CITY OF ALBUQUERQUE

December 14, 2023

Re: Juan Tabo S.C
845 Juan Tabo Blvd. NE
Traffic Circulation Layout
Architect's Stamp 12-14-23 (K21-D019A)

1 SITE PLAN
SCALE: 3/32" = 1'-0"

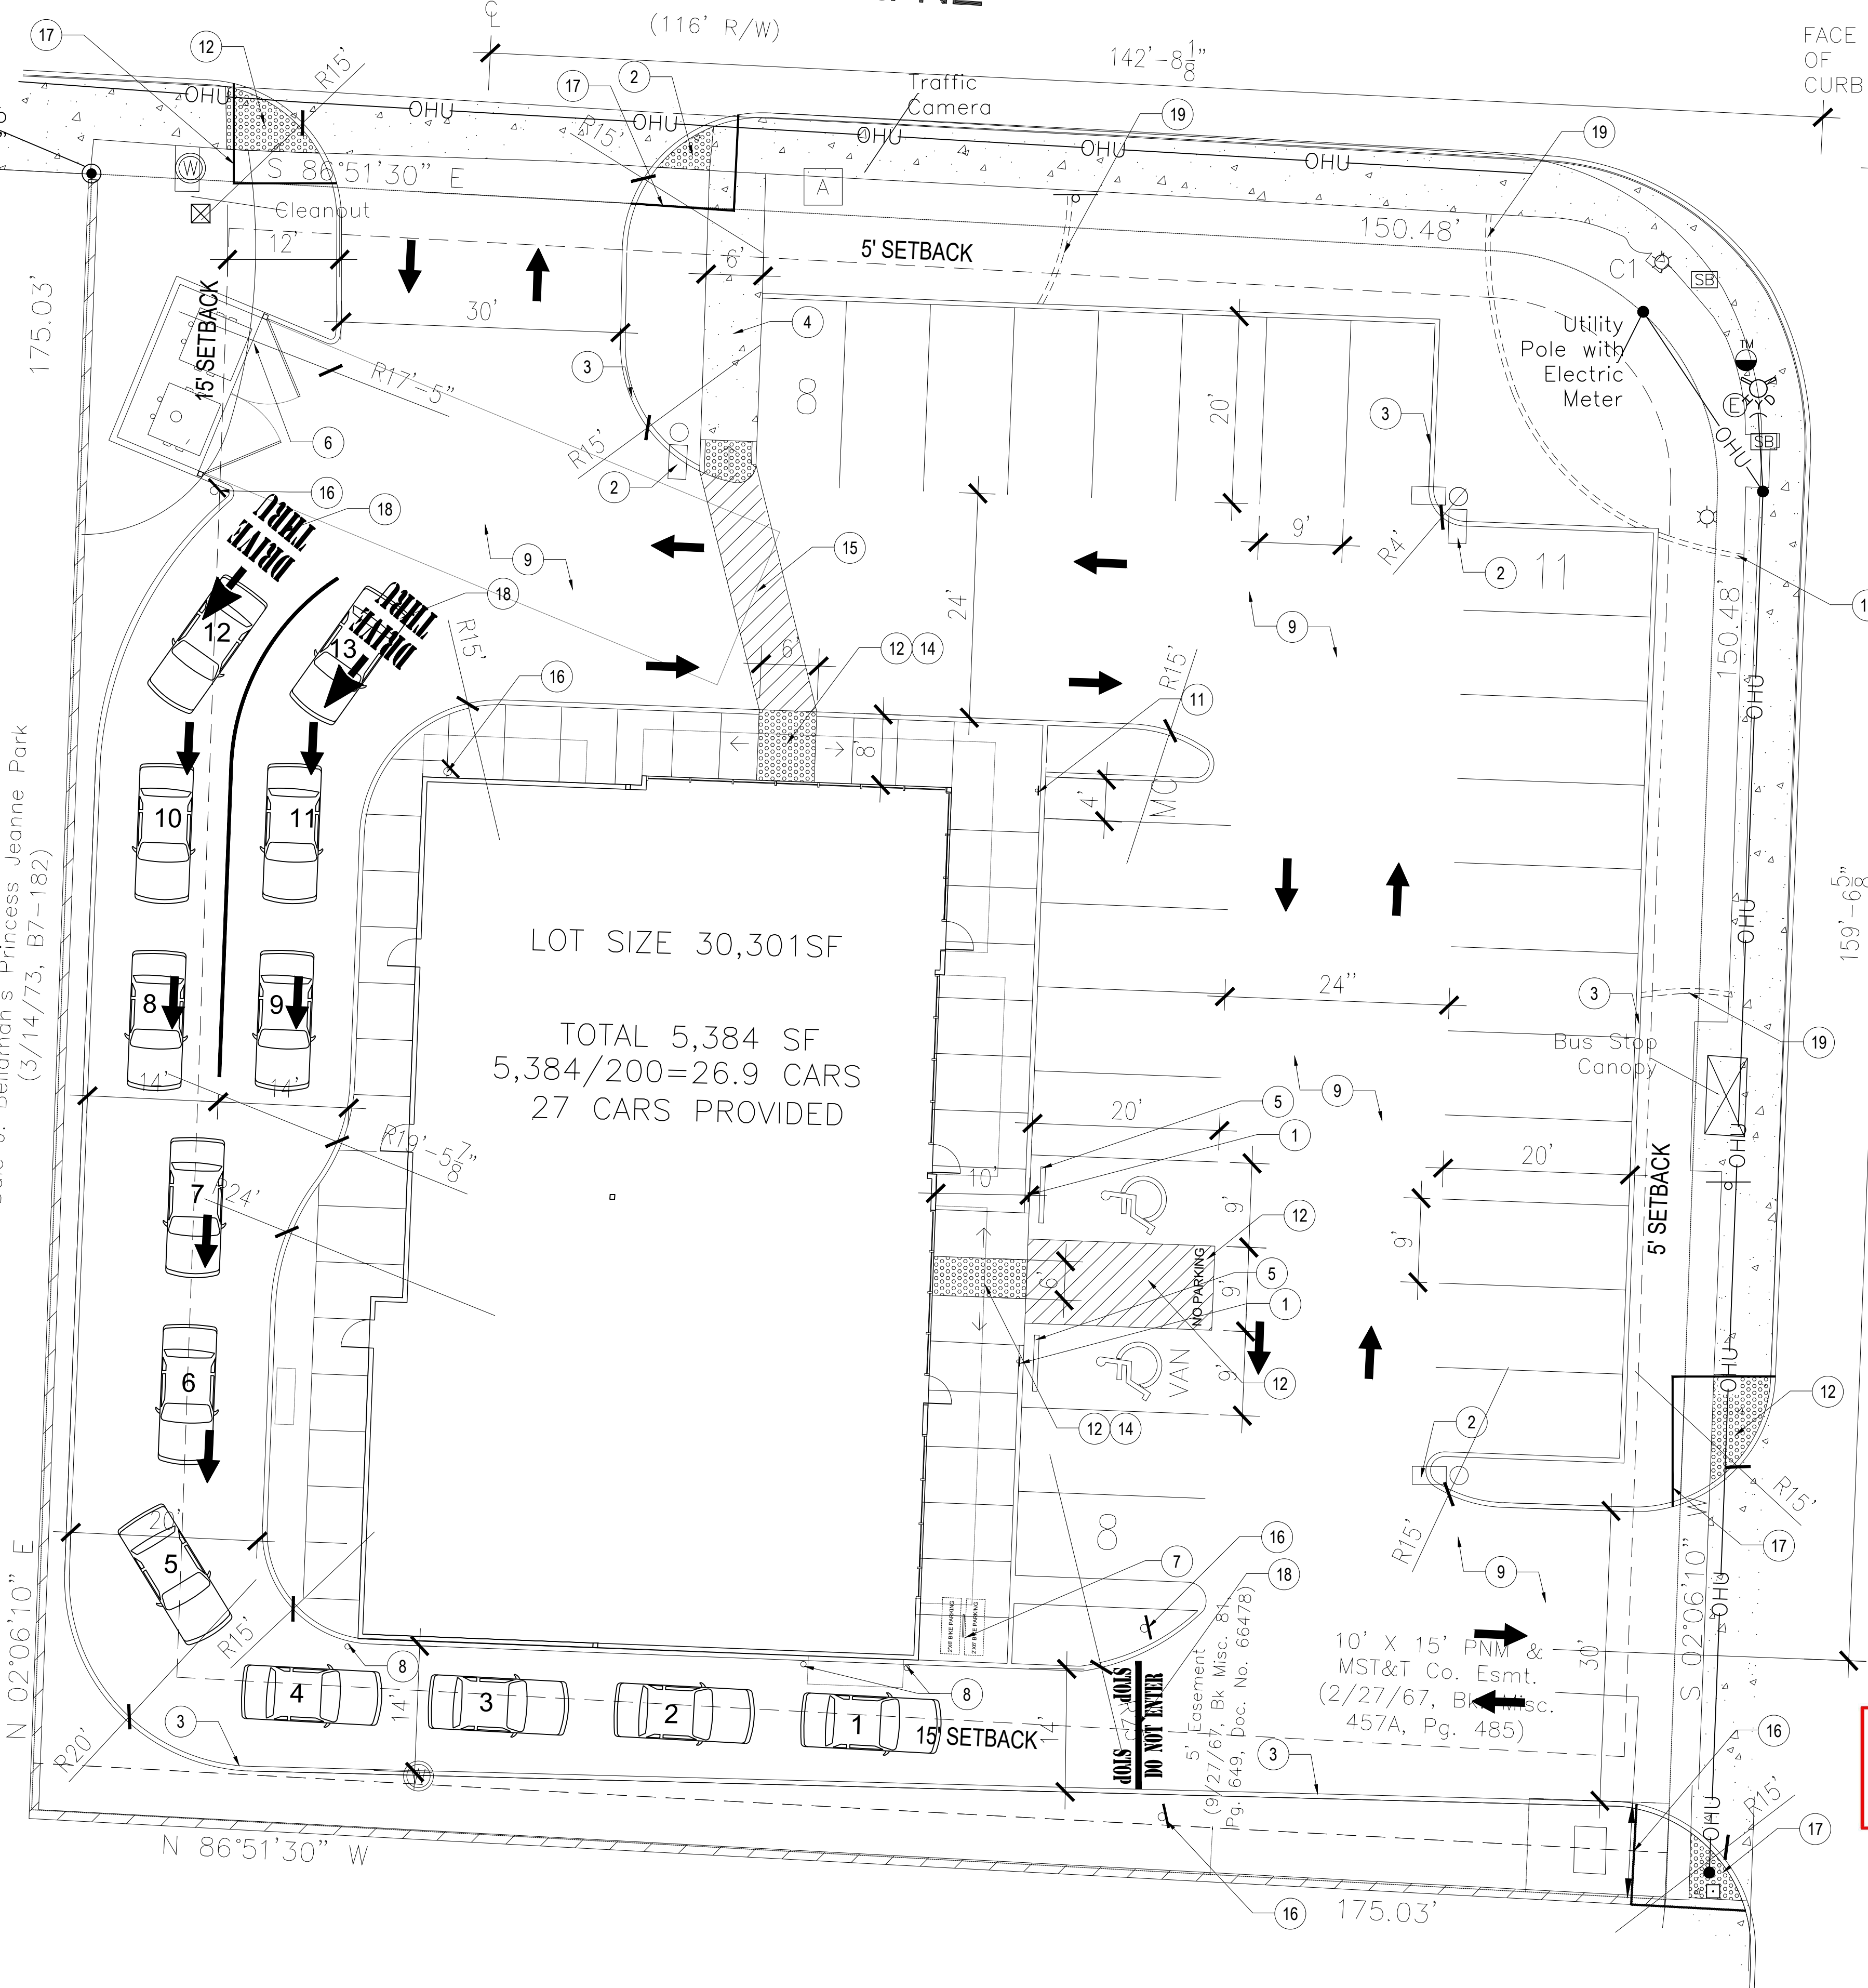
1. Please show a vicinity map showing the location of the development in relation to streets and well known landmarks.
2. List the number of Motorcycle and Bicycle parking spaces required by the IDO.
3. Identify all existing access easements and rights of way width dimensions.
4. Distance from the site access off Lomas Blvd. to intersection must be minimum 300 ft. the distance from the site access off Juan Tabo Blvd. to the intersection must be minimum 200 ft. Please show these dimensions on the site plan.
5. Please provide details for both site accesses.
6. the minimum width for the proposed ADA parking space is 8.5 ft. Please revise ADA parking spaces details.
7. The proposed ADA ramps on the site doesn't match the details for the ADA ramp.

8. Minimum ADA landing area must be 5'X 5'.

9. The ADA access aisles shall have the words **"NO PARKING"** in capital letters, each of which shall be at least one foot high and at least two inches wide, placed at the rear of the parking space so as to be close to where an adjacent vehicle's rear tire would be placed. (66-1-4.1.B NMSA 1978).

10. It is not apparent what type of pavement surface is being proposed. A hard driving surface will be required as part of this proposed project for parking area and drive aisles.

11. All one-way drives shall have "One Way" and "Do Not Enter" signage and pavement markings. Please show detail and location of posted signs and striping.

12. The minimum drive through lane width is 12 feet with a 25 foot minimum radius (inside edge) for all turns. (A 15 foot radius can be used with an increase in lane width to 14 feet). Please dimension all lane widths and radii.

13. Please revise keynotes 9 & 12 and keynote 15 is missing.
14. Motorcycle parking spaces shall be designated by its own conspicuously posted upright sign, either free-standing or wall mounted per the zoning code.

15. The pavement marking "MC" should be shown in the opposite direction for motorcycles entering the parking space.
16. All bicycle racks shall be designed according to the following guidelines:

20. Per the IDO, a 6 ft. wide ADA accessible pedestrian pathway is required from the public sidewalk to the building entrances. Please clearly show this pathway and provide details.

21. Per DPM, a 6 ft. wide ADA accessible pedestrian pathway is required from the ADA parking stall access aisles to the building entrances. Please clearly show this pathway and provide details.

22. ADA accessible pedestrian pathway should not be placed behind parking space or adjacent to a vehicular way. Vehicle and pedestrian/wheel chair conflicts should be avoided as much as possible.

23. Show the clear sight triangle and add the following note to the plan: "Landscaping and signage will not interfere with clear sight requirements. Therefore, signs, walls, trees, and shrubbery between 3 and 8 feet tall (as measured from the gutter pan) will not be acceptable in the clear sight triangle.
24. Please specify the City Standard Drawing Number when applicable.
25. Unused curb cuts must be replaced with sidewalk and curb & gutter. A build note must be provided referring to the appropriate City Standard drawing.
26. Add a note stating "All broken or cracked sidewalk must be replaced with sidewalk and curb & gutter." A build note must be provided referring to the appropriate City Standard drawing.
27. Please provide a letter of response for all comments given.

7 BICYCLE RACK
SCALE: 3/4"=1'-0"

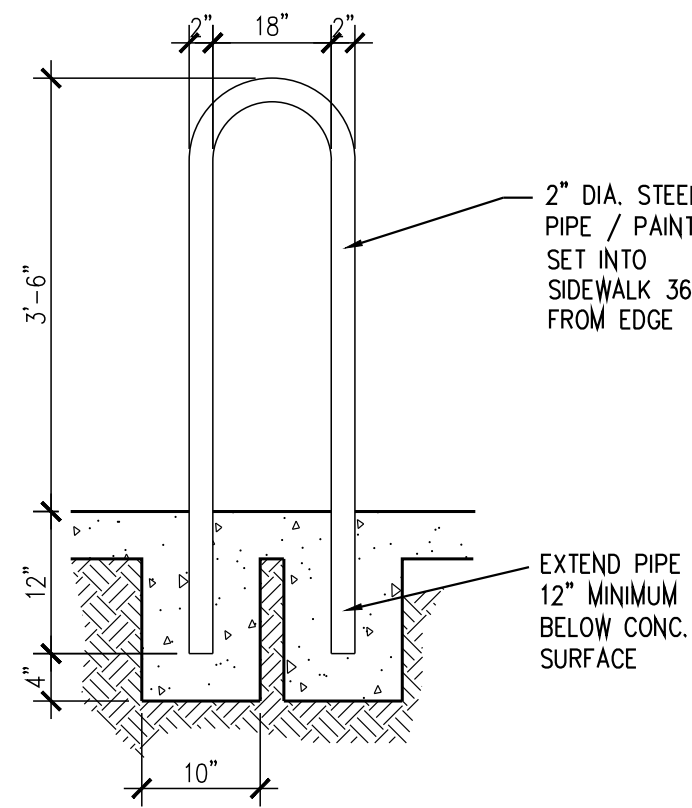
- a. The rack shall be a minimum 30 inches tall and 18 inches wide.
 - b. The bicycle frame shall be supported horizontally at two or more places. Comb/toaster racks are not allowed.

- c. The rack shall be designed to support the bicycle in an upright position. See the IDO for additional information.
 - d. The rack allows varying bicycle frame sizes and styles to be attached.

- e. The user is not required to lift the bicycle onto the bicycle rack.
 - f. Each bicycle parking space is accessible without moving another bicycle.

17. Bicycle racks shall be sturdy and anchored to a concrete pad.
18. A 1-foot clear zone around the bicycle parking stall shall be provided.
19. Bicycle parking spaces shall be at least 6 feet long and 2 feet wide.
